Re: Objection To Building At 21 Hawke Close, Rustington. Planning Ref. R/151/14/HH.

We live at the rear of the above and would like to strongly object to the dormer windows that have been installed as part of a loft conversion.

Proposed Front Elevation. Scale 1:100

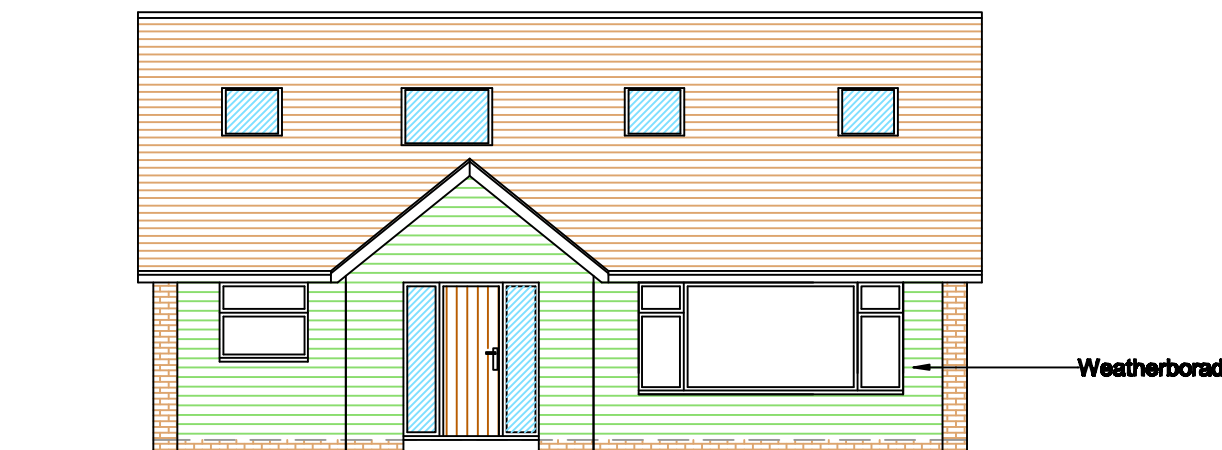
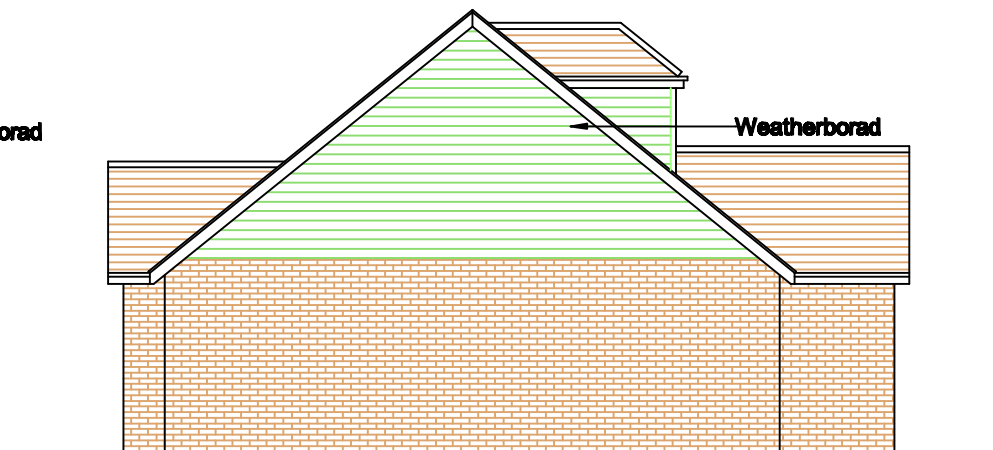
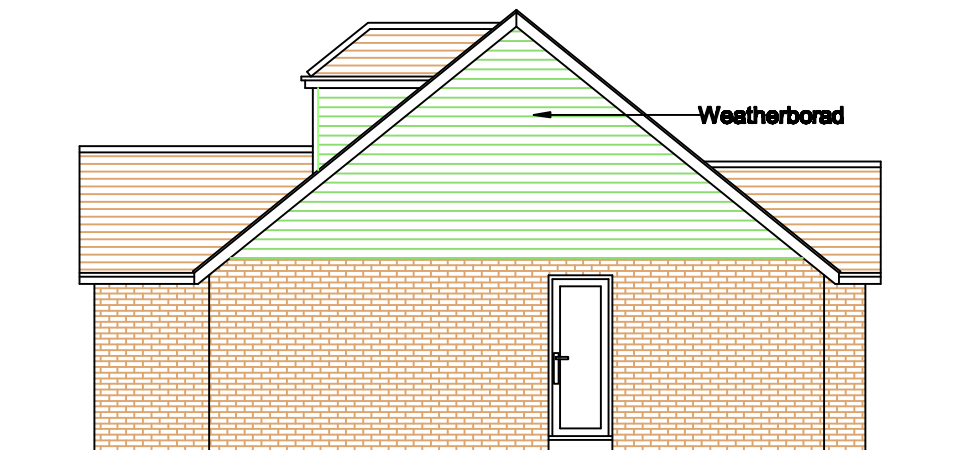
We are also given to understand that the conversion was erected under permitted development but feel it does not comply with all conditions required. Particularly in respect of the cement board cladding. These weather boards in no way meet the requirements that all materials used shall be similar to existing and therefore, is totally out of character with other buildings in the area.

Proposed Rear Elevation. Scale 1:100

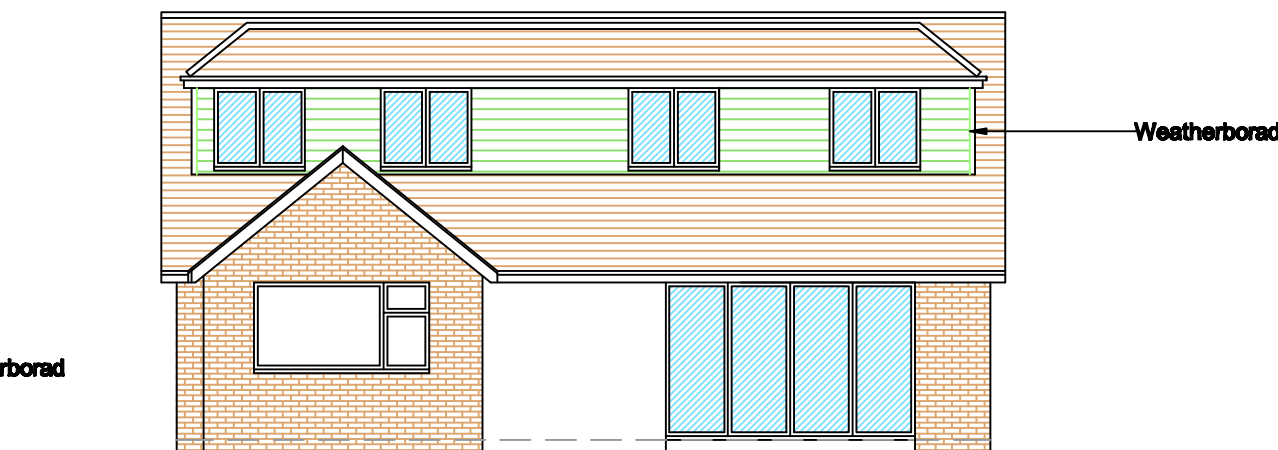
All four windows at the rear look directly into our bedrooms and gardens and two of the windows directly into our lounge and kitchen. We consider that this building which is only 60-70 feet from our bungalow presents a total invasion of our privacy.
